Rezoning Transportation Analysis

Petition Number: #2022-070

Rezoning Transportation Analysis

**RZ-2.0**

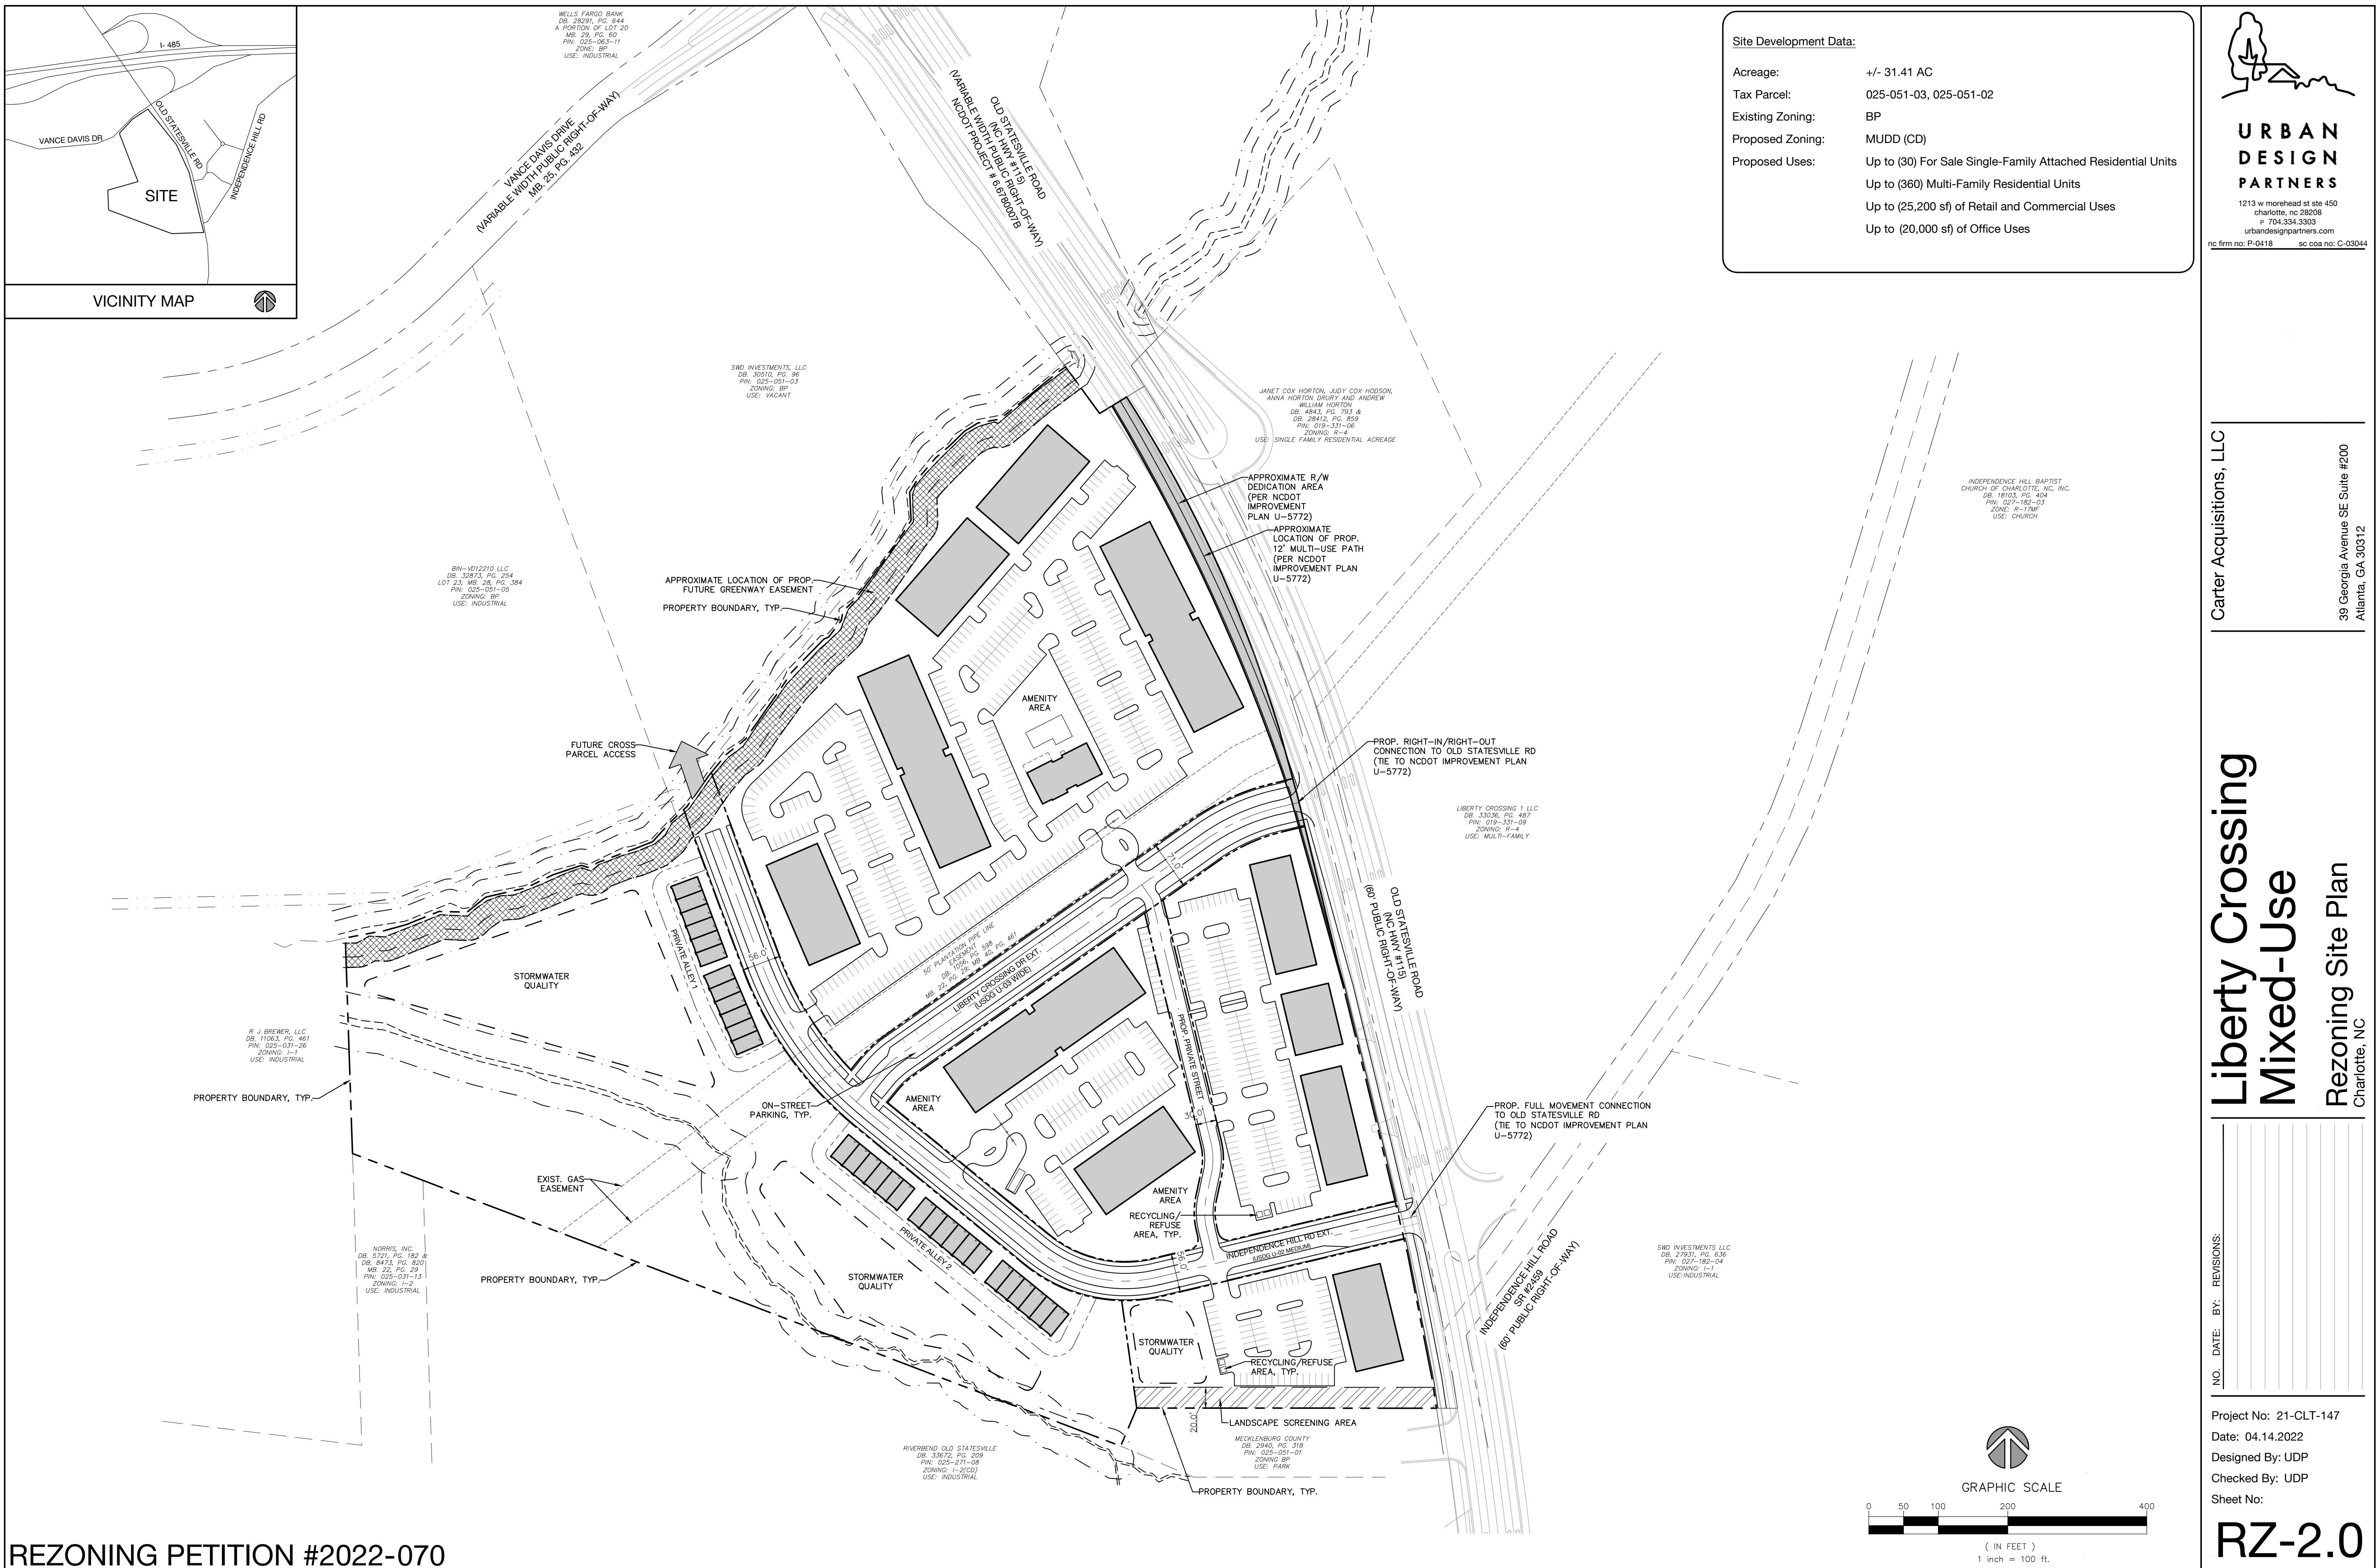
~~**Outstanding Comment From 9-29-22:** Label and dimension the curb and gutter from the centerline for each road on the site plan.~~

- ~~3. Revise site plan to dimension the proposed right-of-way along Old Statesville Road to be dedicated. The ROW dedication shall include the necessary widths to accommodate the NCDOT U-5772 project.~~

Clarifying Comment (10-26-2022): Dimension ROW along Old Statesville Road from the centerline of the roadway.

- ~~4. Revise site plan and conditional note(s) to identify Independence Hill extension and Liberty Crossing Drive extension roadways as public or private.~~

- ~~5. Revise site plan to dimension the 8 foot planting strip, and 8 foot sidewalk along the internal public roads per Chapter 19.~~

- ~~7. Site plan and conditional note(s) revisions are needed to commit to constructing a temporary turn around at the proposed future cross parcel access on Independence Hill Road extension in accordance of CLDSM 11.18B.~~
